**DIAMOND COVE GENERAL STORE  
 LIFE SAFETY PLAN**

**MRS. ALEXANDRA WIGHT**  
 GENERAL STORE, GREAT DIAMOND ISLAND  
 PORTLAND, MAINE 1231

1 SAFETY PLAN VIEW
 Scale: 1/4"=1'-0"

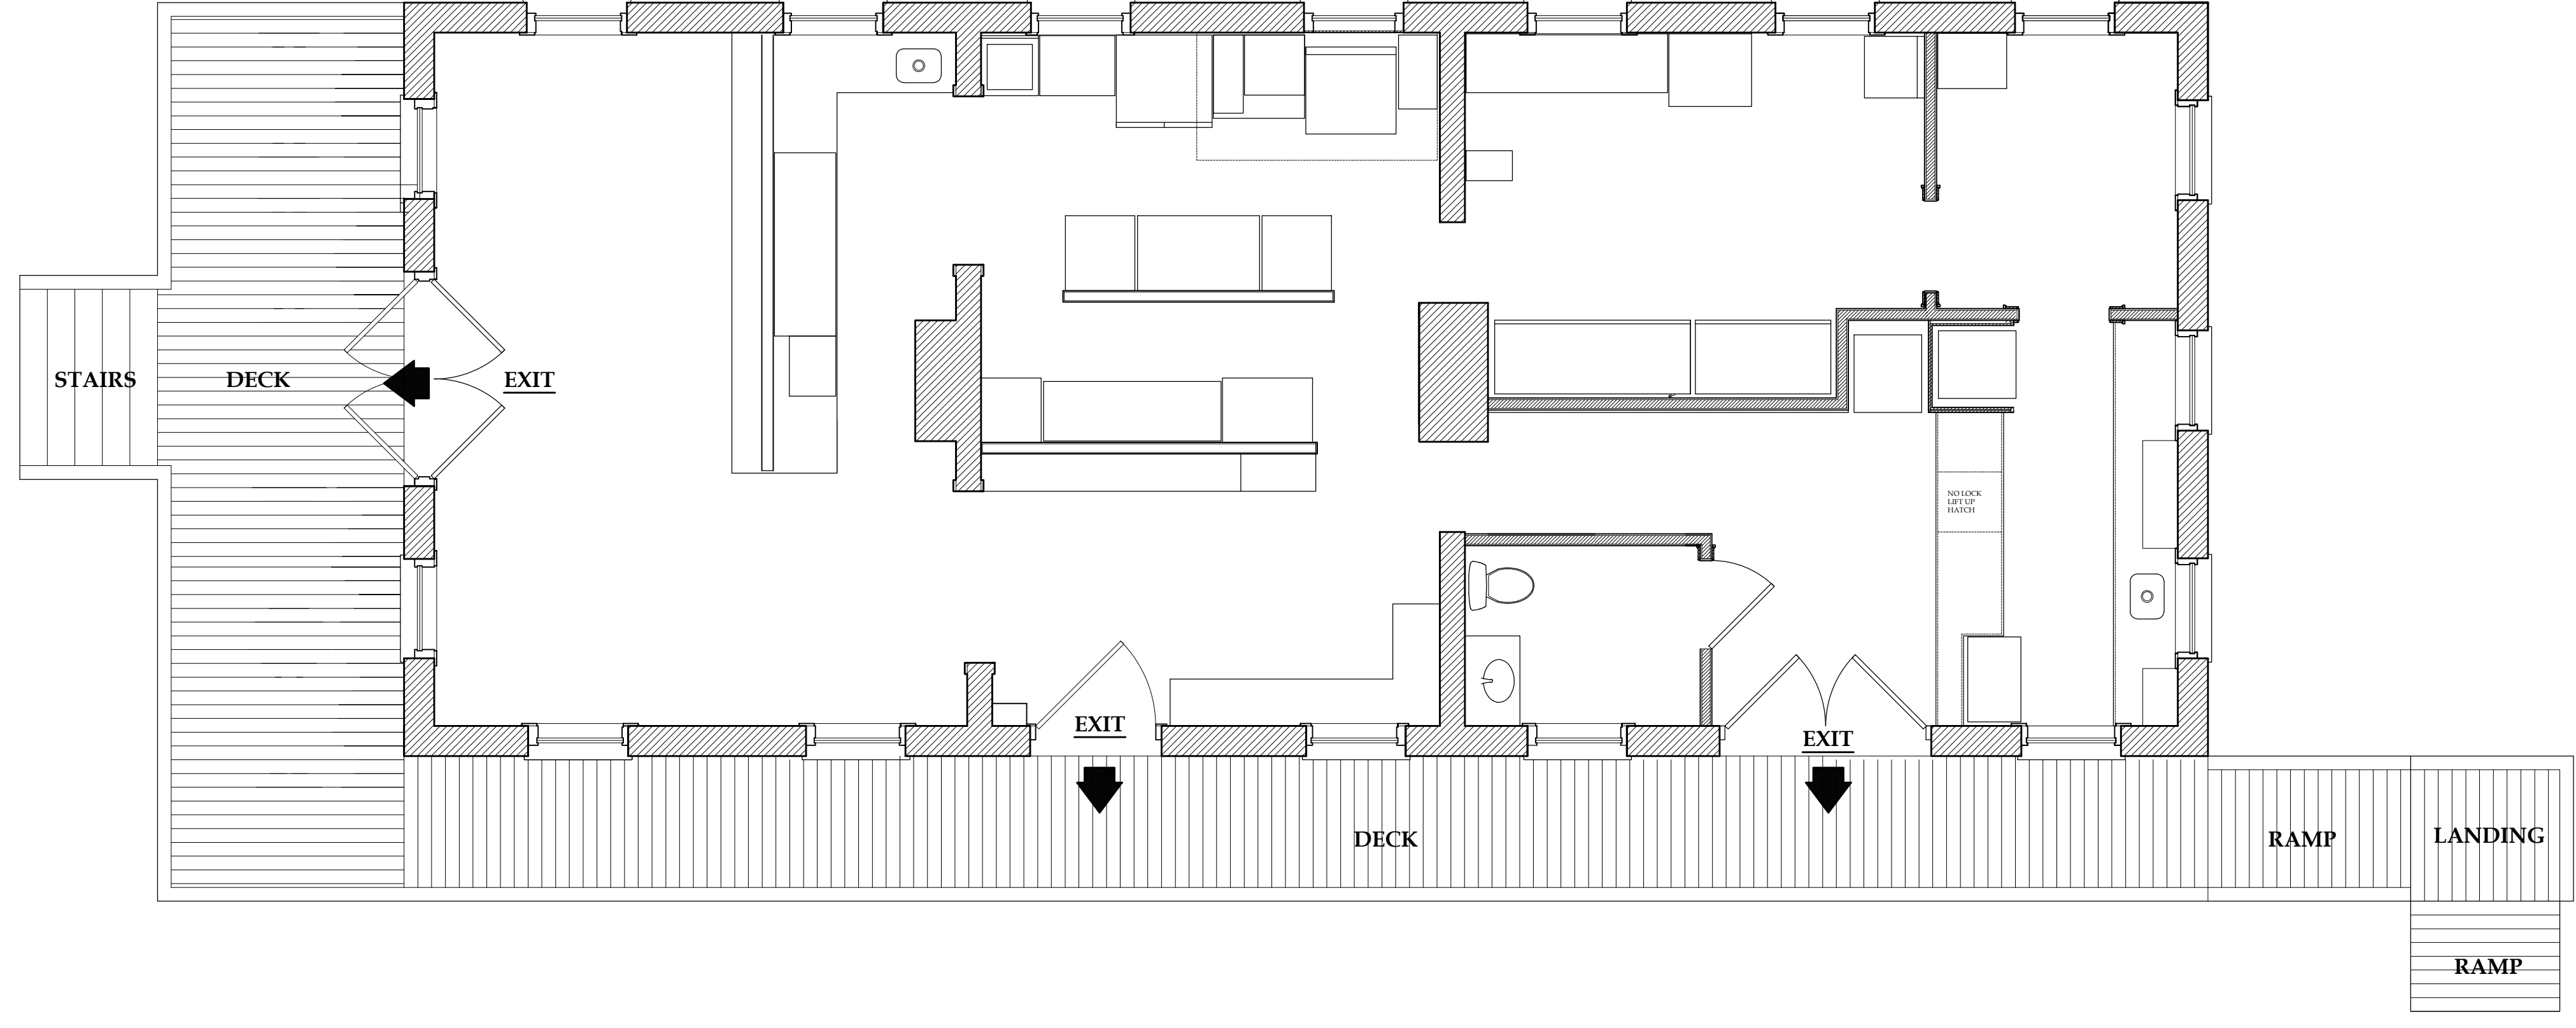
Your Life Safety plan will need to include the following information:  
 1 Square footage of the all the rooms / uses shown on the plan  
 2 Show the area that you will provide table and chairs.  
 3 Show longest travel distance to outside.  
 4 Is the way out from behind the counter in the general store to the outside through the storage / kitchen areas?

Addition information needed:  
 1 What in the height of the deck outside and is there a guard or railing around it?  
 2 What is the pitch of the ramp leading to the deck?
